From: Andrew Wood
Sent: 17 May 2019 13:00
To: Planning.Responses
Subject: FW: planning application FG/220/18/PL New house in garden of Elm Lodge, Tamarisk Way, Ferring, BN12 5ER

From: [REDACTED]
Sent: 03 March 2019 11:28
To: Andrew Wood
Subject: planning application FG/220/18/PL New house in garden of Elm Lodge, Tamarisk Way, Ferring, BN12 5ER

PROPOSED WEST (SIDE) ELEVATION 1:50.

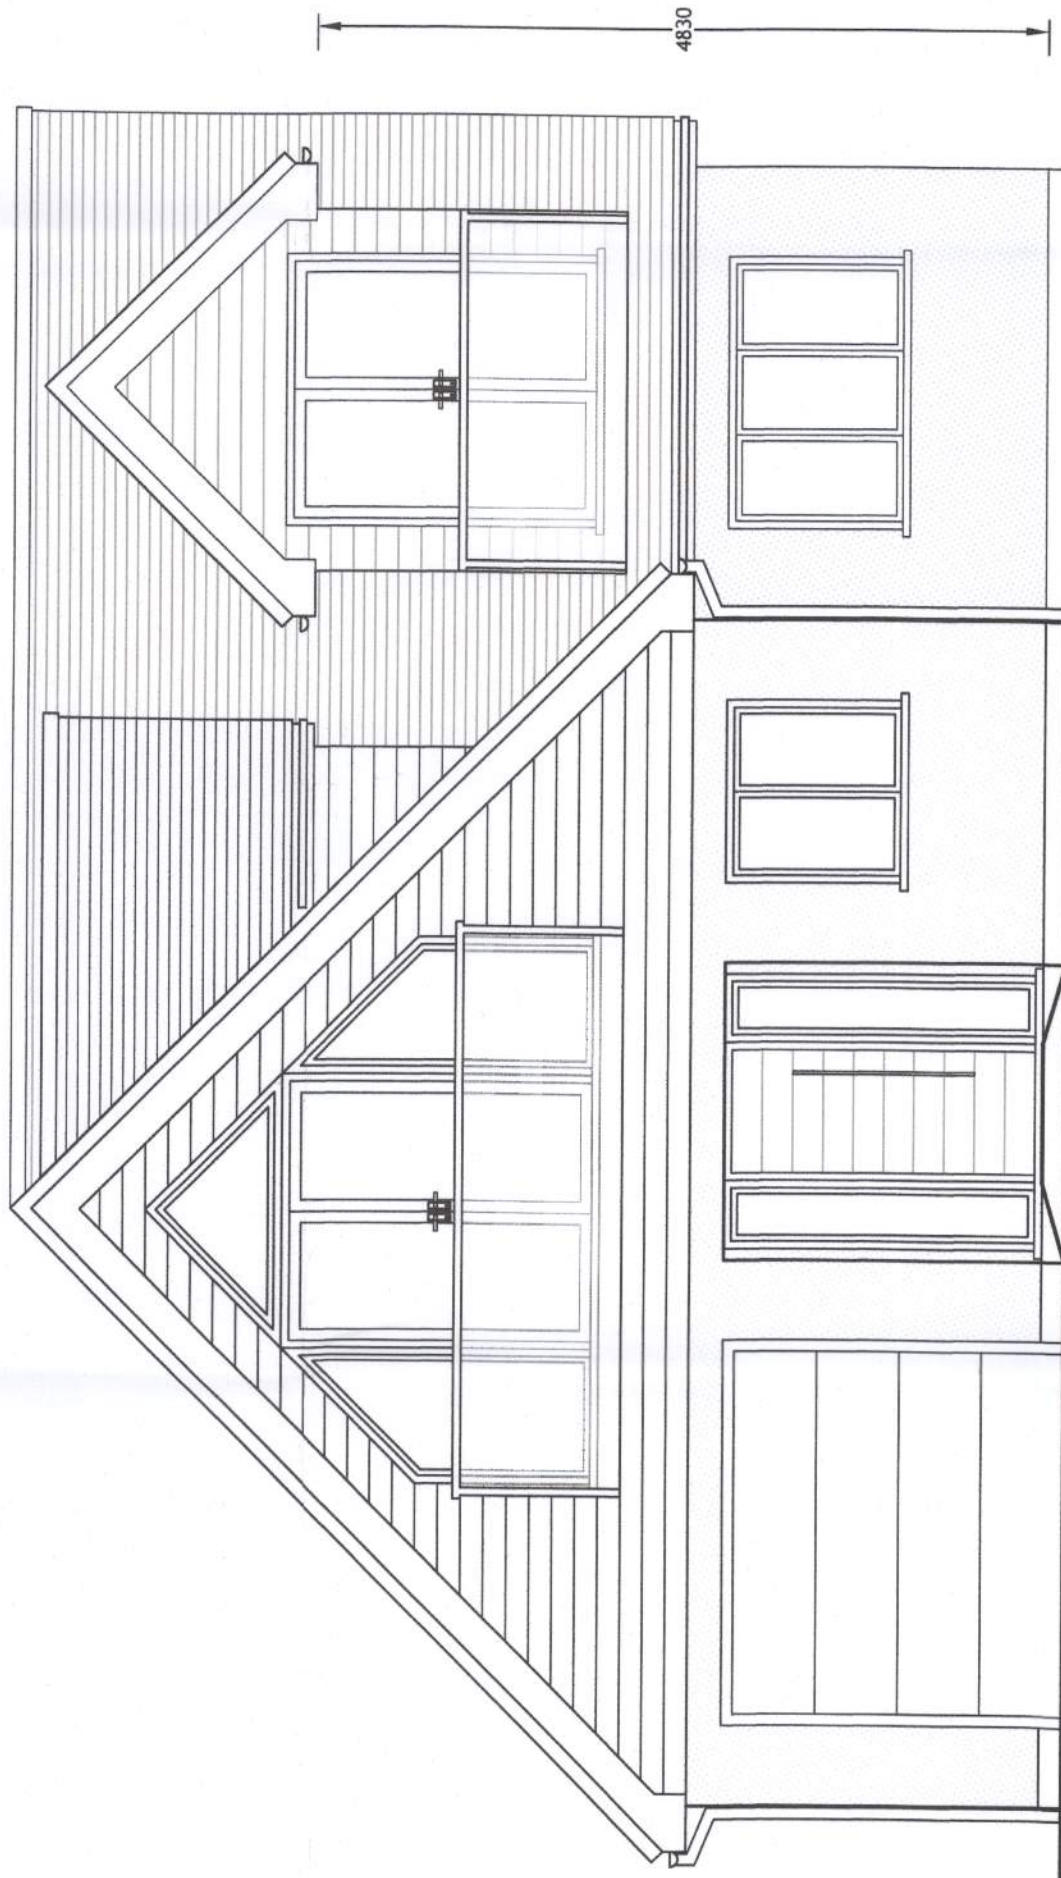
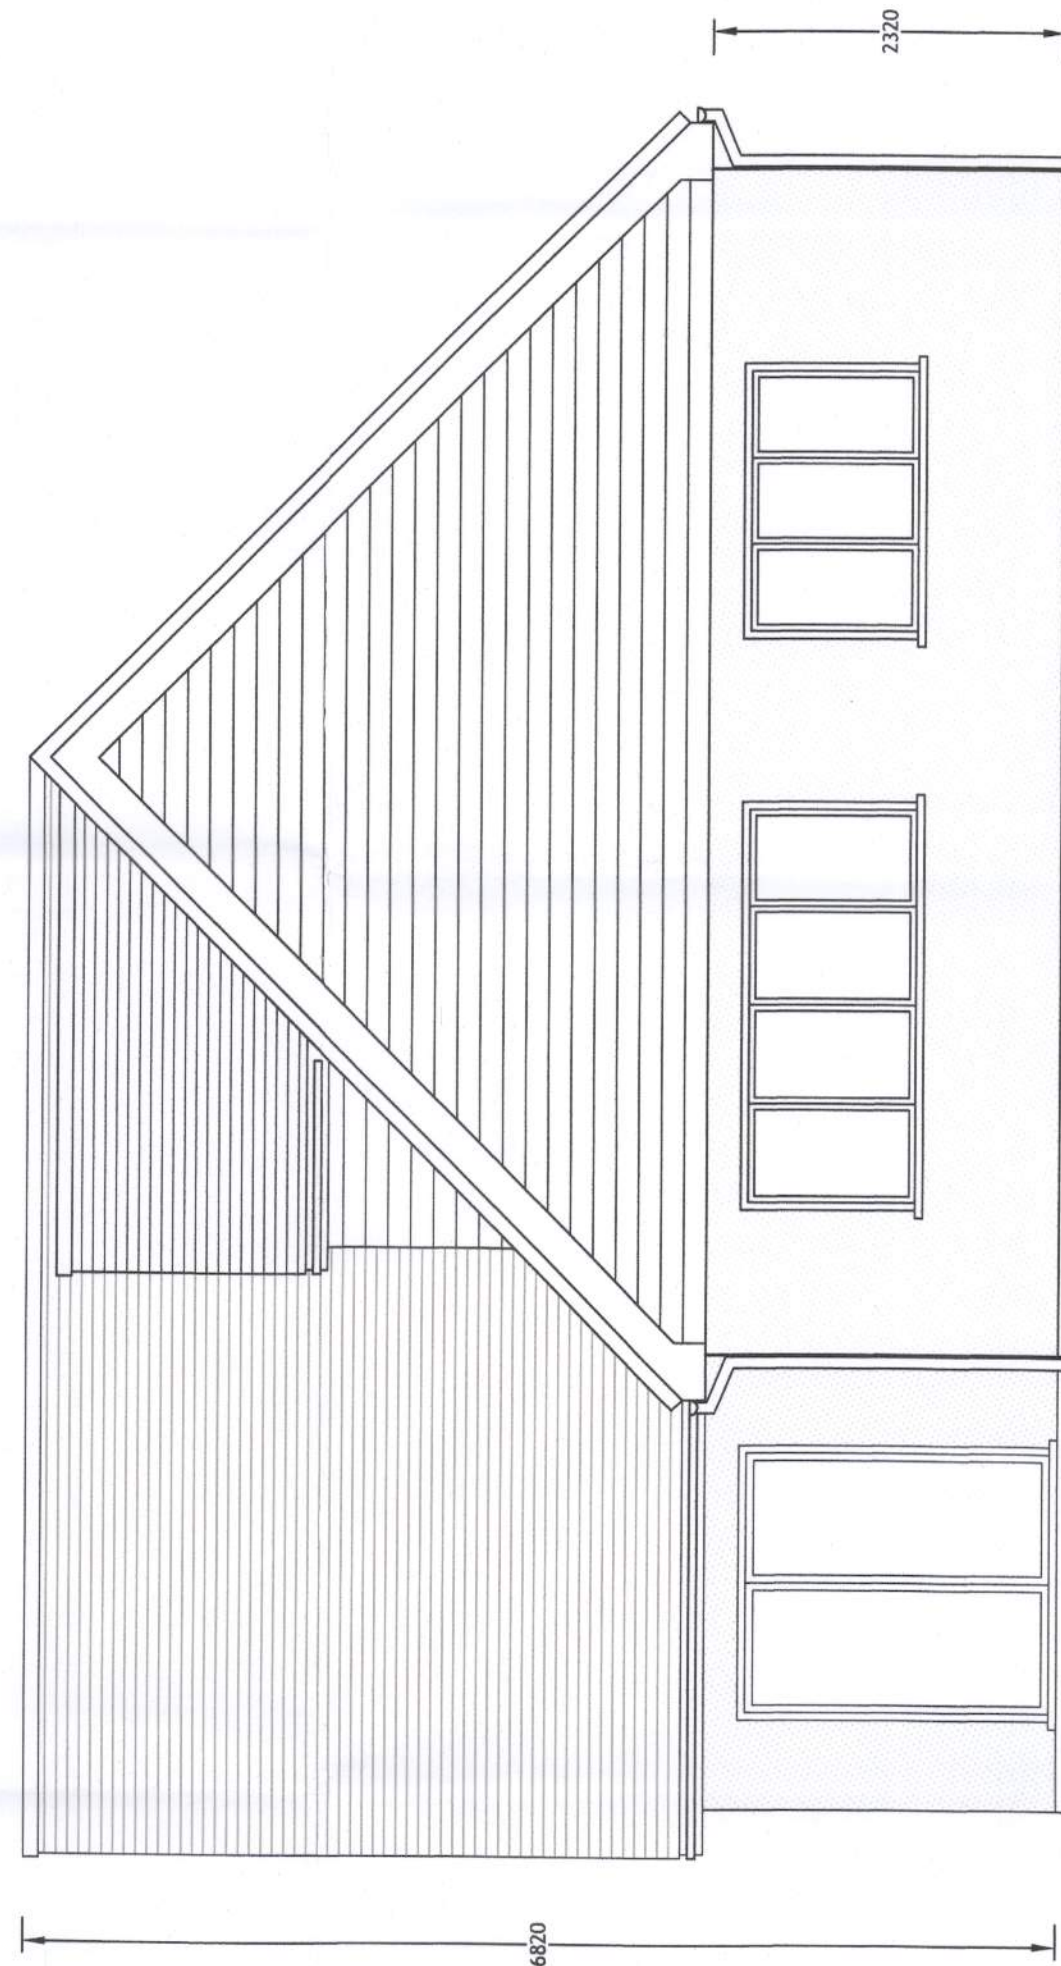
The proposed house plans call for 3 full length balcony windows on the first floor, 2 of which will look down directly into habitable areas and gardens of Magalia (one of these windows fully covers the entire 1st floor gable). We would point out that this is in addition to a third window which is to be installed in Elm Lodge and which is in fact less than the recommended distance from Magalia (see discussions held at a site visit from a member of the Arun Planning Dept. in November last year). This presents an excessive and unacceptable intrusion of privacy and we believe this to be contrary to the requirements of the Arun Local plan as detailed above

The ‘post- modern’ style of the proposed house and alterations to Elm Lodge are highly suitable for the urban Home Counties, but are completely out of character and sympathy with the houses in and around Tamarisk Way and along Sea Lane. The use of cladding, blue slate tiles and grey windows bears no resemblance to any building materials used in the vicinity of Tamarisk Way and would stand out like a ‘sore thumb’.
